15/11/2019

Tweed Valley Hospital Stage 2 (SSD-10353)
Response to Submissions

#### FACADE TYPE PLANS MHB - LEVEL 03

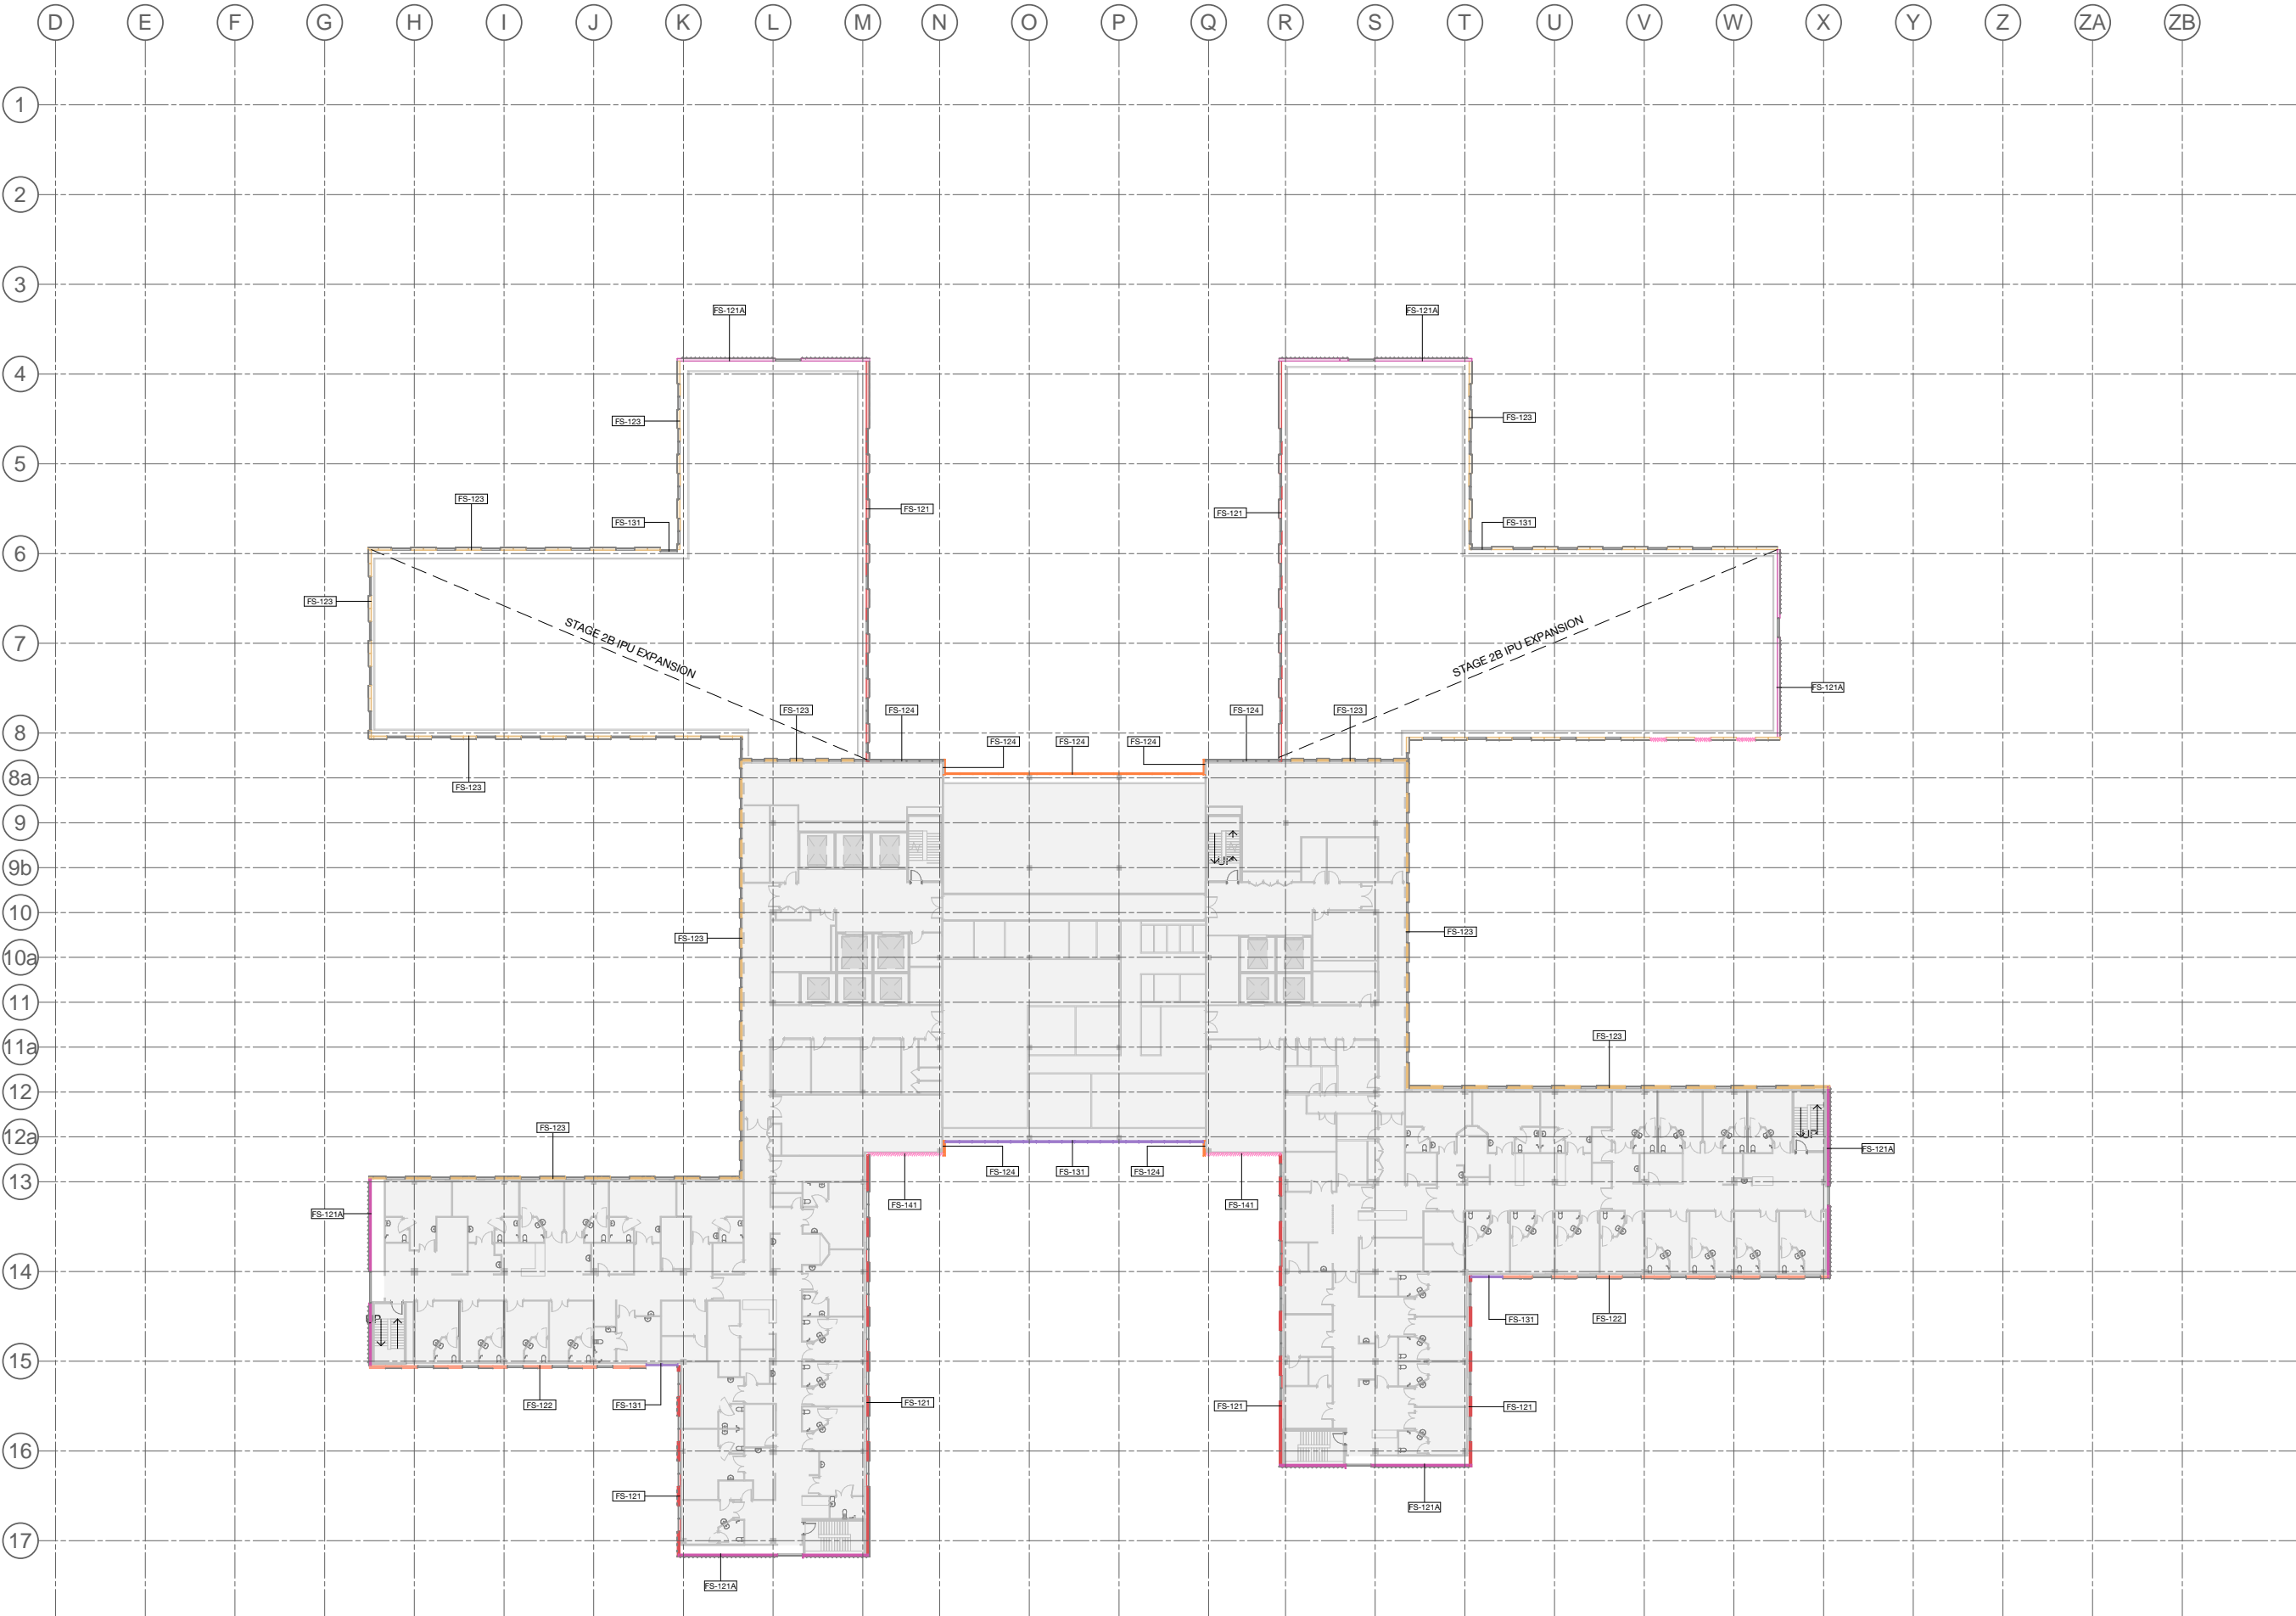
- sky gardens to the north-west of the shared administration zone on Level 3.
 - multiple sky gardens on Levels 4 and 5.
 - use of shared stairs between floor levels in lieu of the current emphasis on lifts.
